From: Bruce Taunton <Bruce.Taunton@arun.gov.uk>
Sent: 03 March 2022 11:39
To: Planning.Responses <Planning.Responses@arun.gov.uk>
Subject: RE: Planning Consultation on: BR/38/22/PL

Application No: BR/38/22/PL
Registered: 15th February 2022
Site Address: 18-20 London Road Bognor Regis PO21 1PY
Grid Reference: 493561 99159
Description of Works: Part conversion and extension of existing building to provide 6 additional storeys over existing rooftop, to provide for up to 104 No student residential units, with access from Bedford Street, associated servicing and ancillary accommodation, entrance and staircore extension to existing building to provide access from Bedford Street. (Resubmission of scheme approved under reference BR/270/18/PL). This application may affect the setting of listed buildings and may affect the character and appearance of nearby conservation areas. This application is in CIL Zone 4 (Zero Rated) as other development.

Image 1: 3 Storey Frame

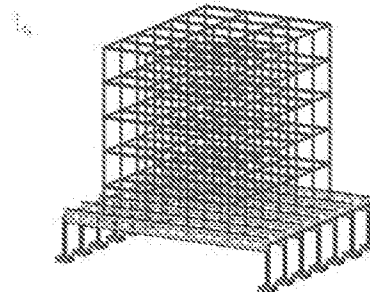
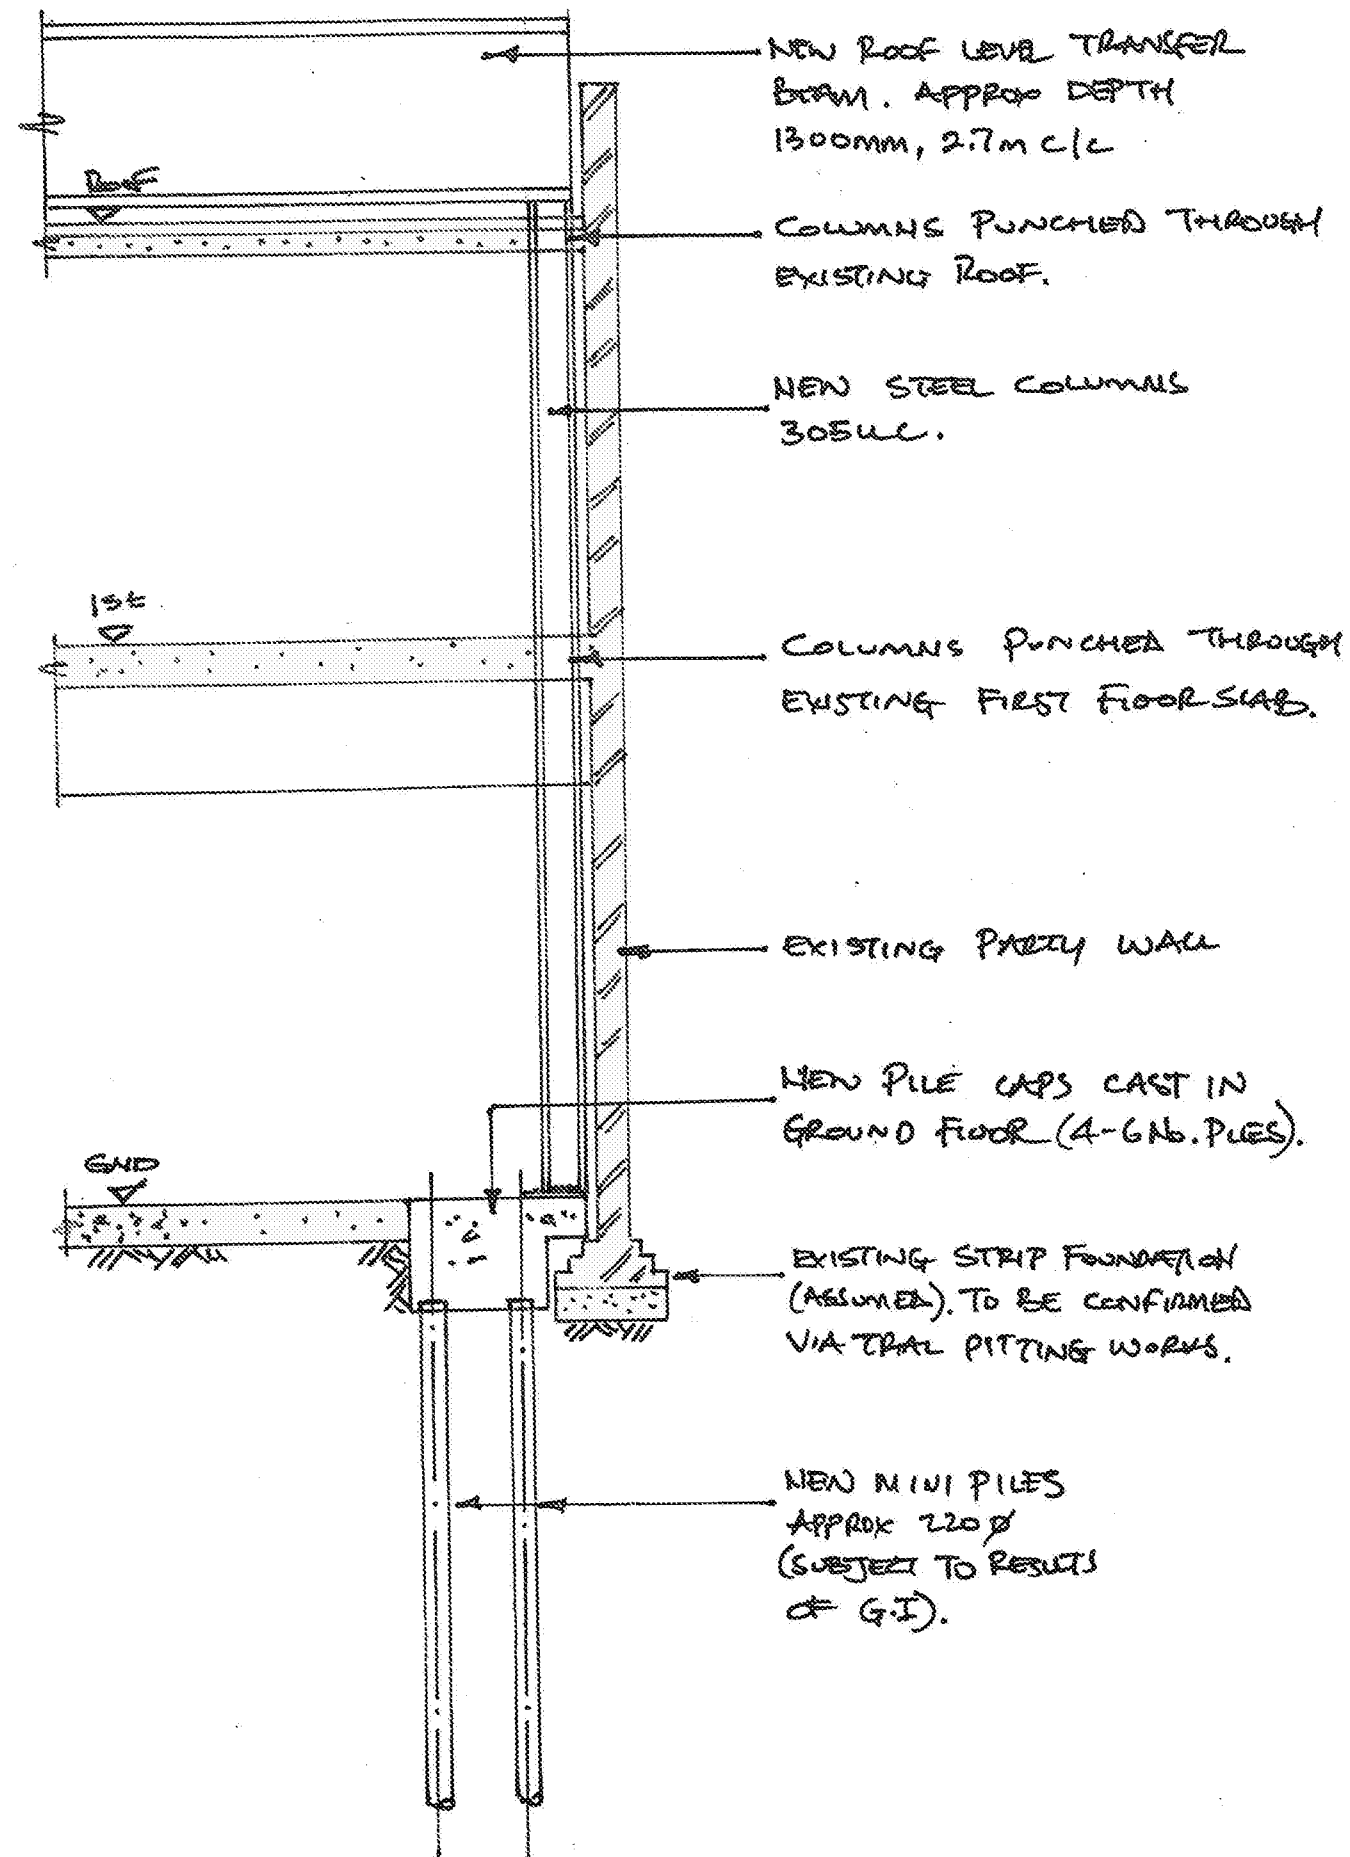
I have reviewed the proposals put forward for the structural scheme and consider the general principles provided could be adopted for the solution. The addendum feasibility report adds a more insight into the proposed structural scheme with the large corner column sizes that support the plate girders more in line with what I would expect due to sway rather than just 305 UC columns. The reinforced stair core is also welcome again for the reasons of stability.
